Stage 1 Road Safety Audit

Gort Town Centre Public Realm Scheme

On behalf of **Galway County Council**

October 2024

PARKING ALLOCATION PLAN

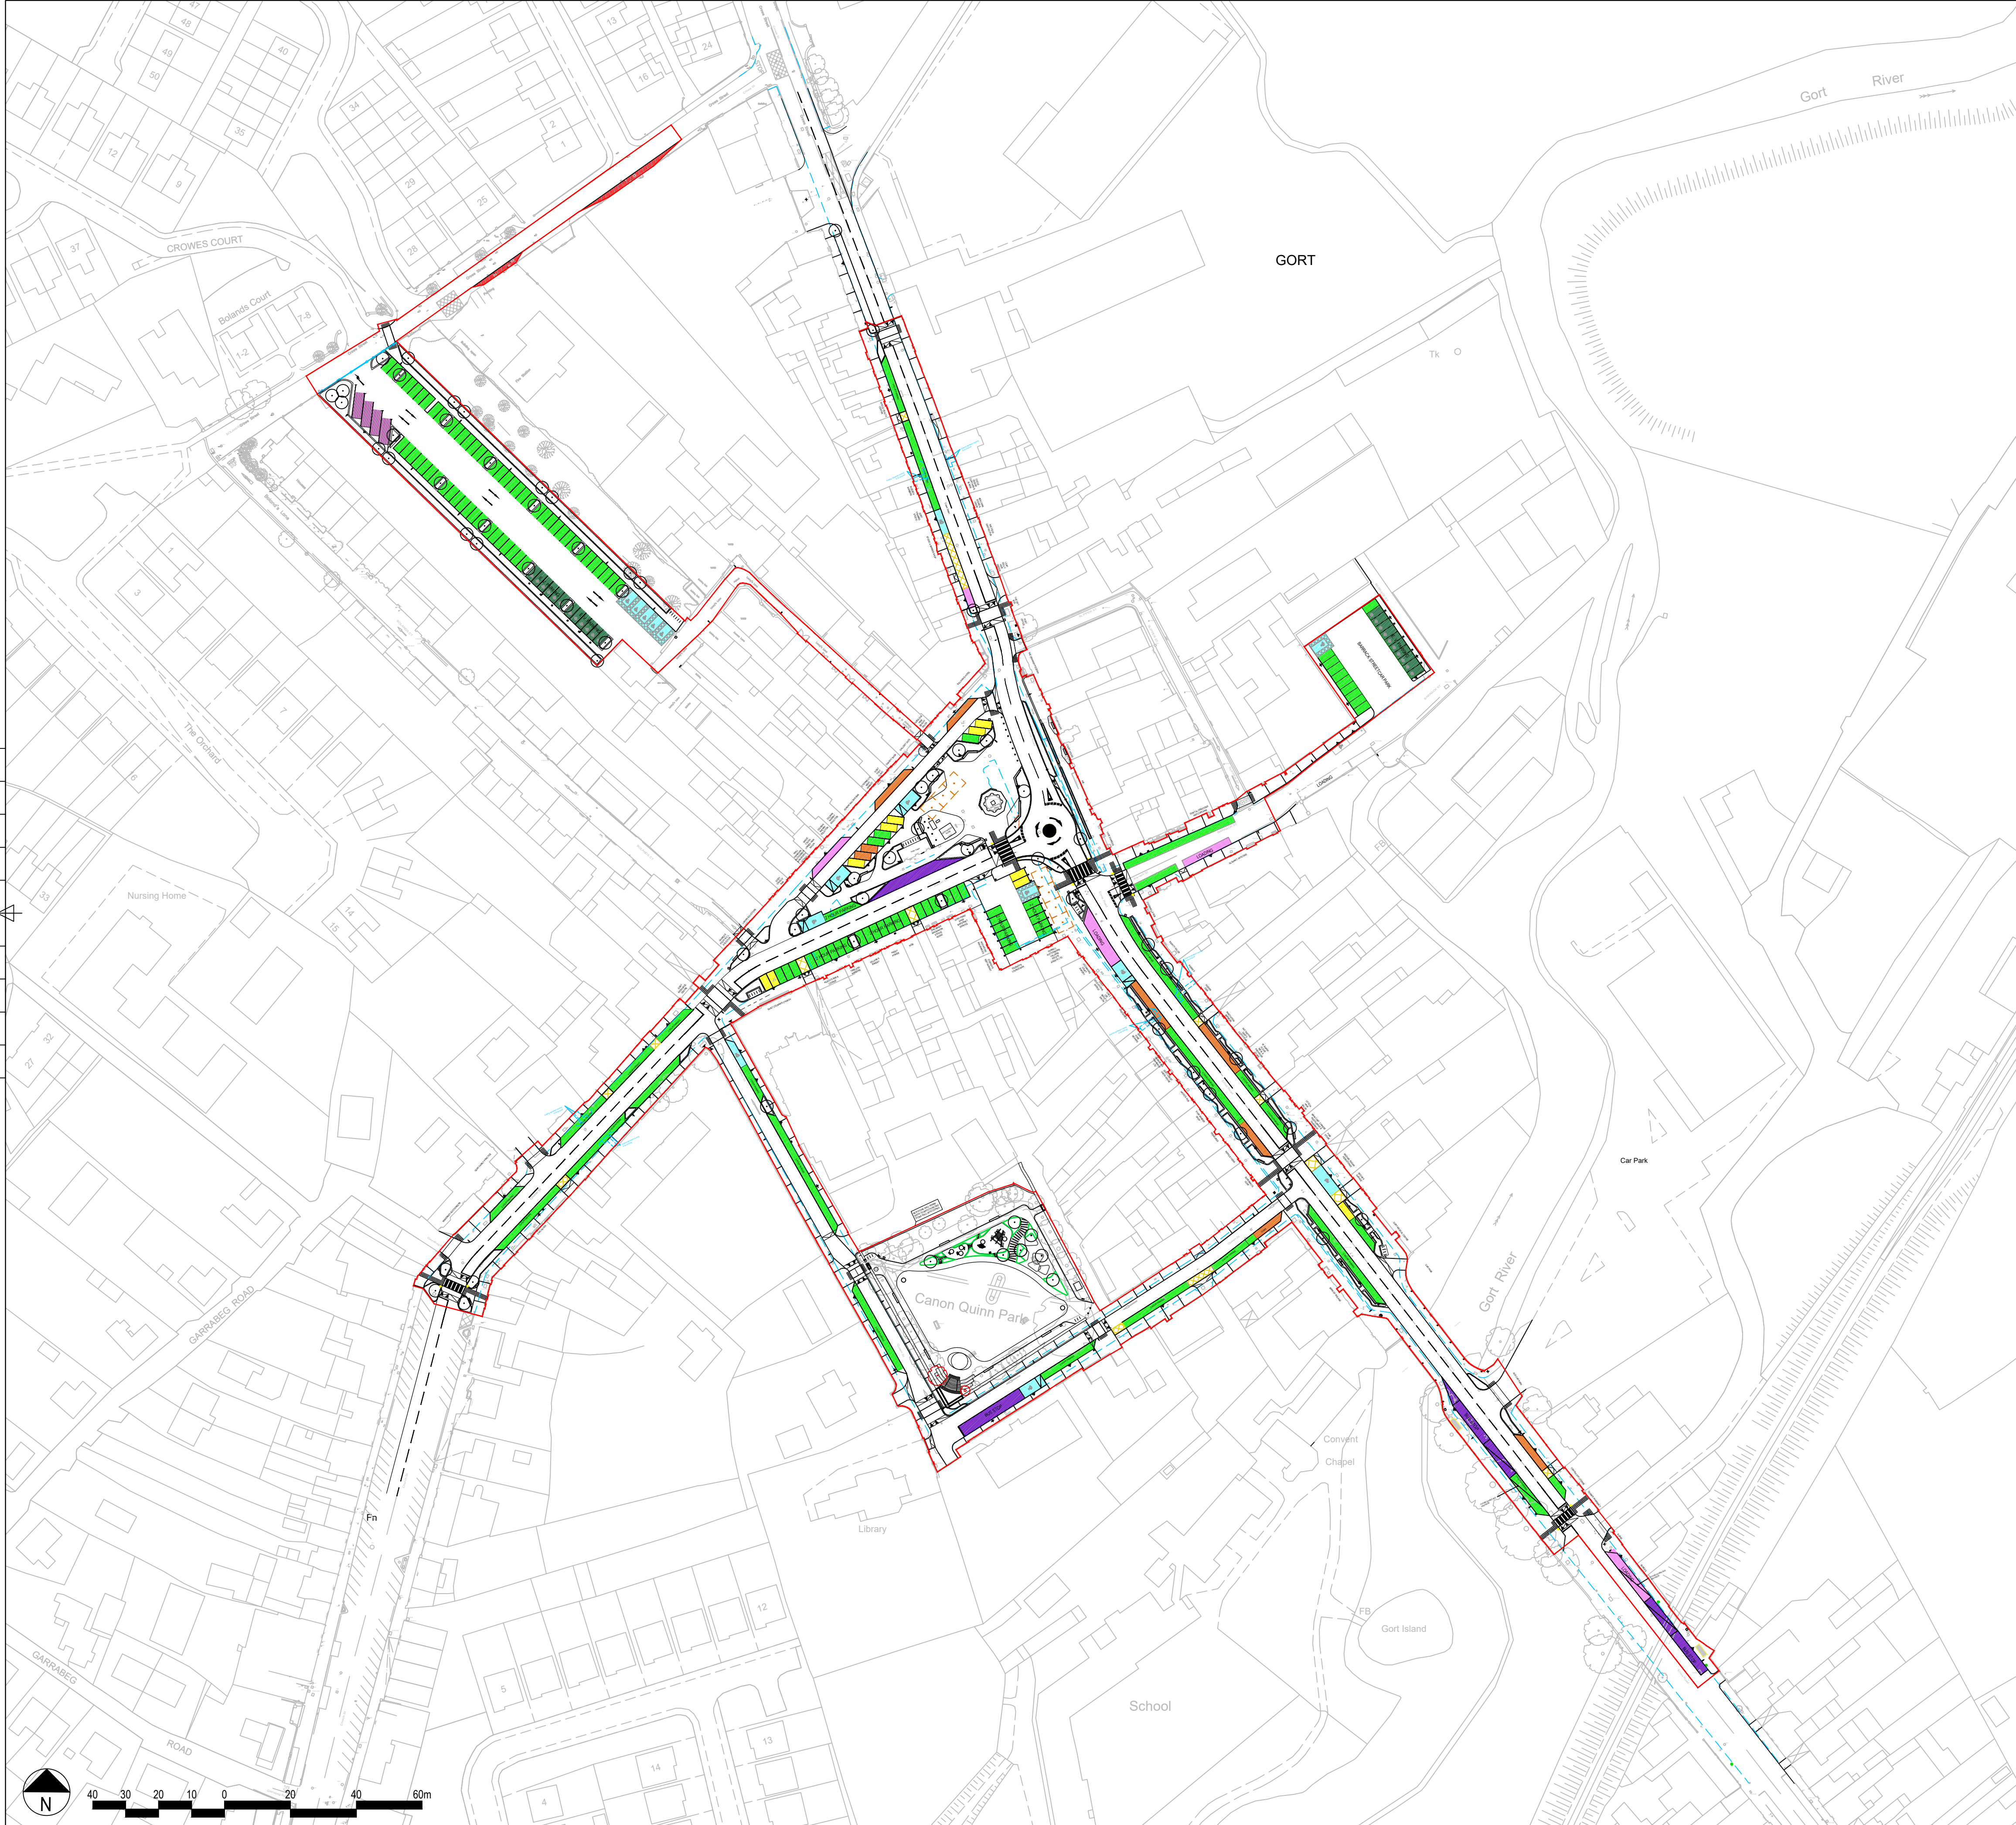
Problem: RV parking is indicated near the entrance to the car park. It is not clear how long vehicles are meant to enter / exit these spaces. It is likely the users will drive forward into the space and reverse back out of the car park junction in order to exit.

Recommendation: The RV spaces should be relocated where entry and exit to the car park can be achieved without need to reverse towards entering vehicles.

3.3.2	Yes	Yes		
3.3.3	Yes	Yes		
3.3.4	Yes	Yes		
3.3.5	Yes	Yes		
3.3.6	Yes	Yes		
3.3.7	Yes	Yes		
3.3.8	Yes	Yes		
3.3.9	No	Yes	We have carefully located the crossing at this location to ensure the best possible vis- ibility given the bend in the road. In addition this crossing is a raised table. All vegetation will be ground cover to ensure visibility

DRAWING TITLE
LANDSCAPE GENERAL ARRANGEMENT

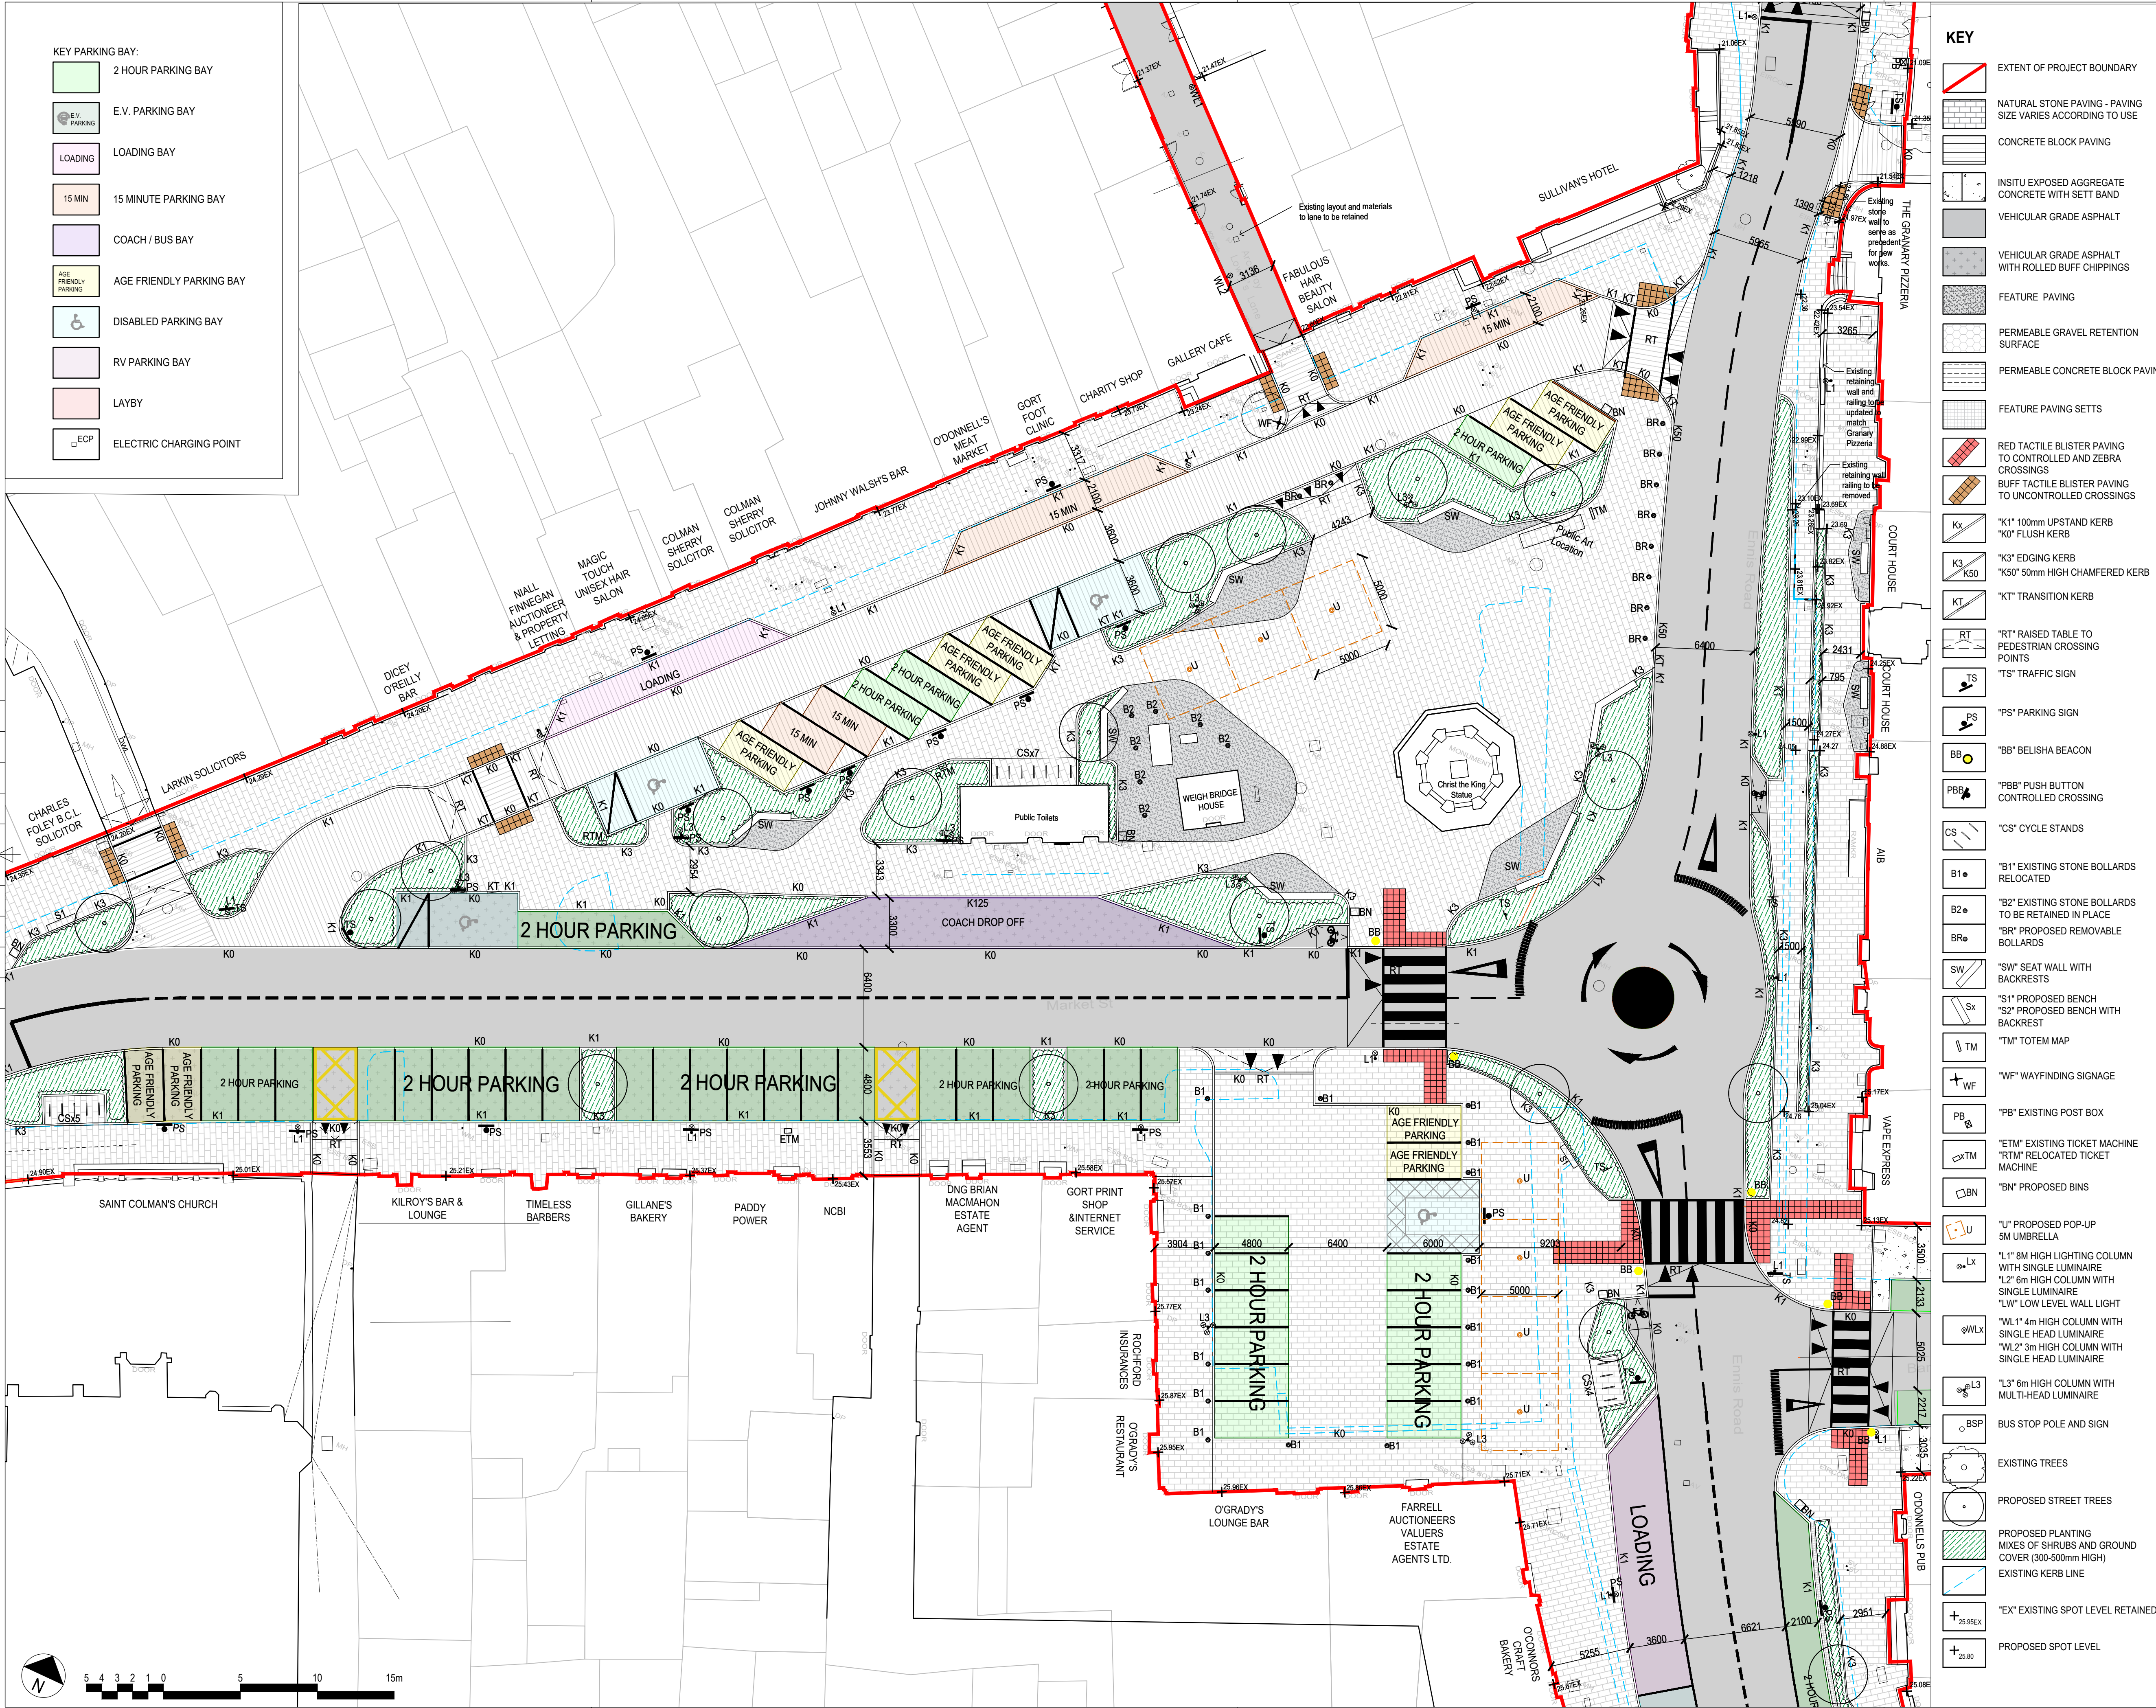
Problem: The paving plan indicates the kerb returning into the HGV access. Motorists may believe vehicles have priority at this junction, yet pedestrians are not advised to take care for vehicles here.

Recommendation: Due to the proximity of the tactile paving for the adjacent controlled crossing, tactile paving could be confusing if located for this entrance. The Design Team should remove the radius kerbs leading to the access lane and treat this area as a footpath crossover, where pedestrians have priority.
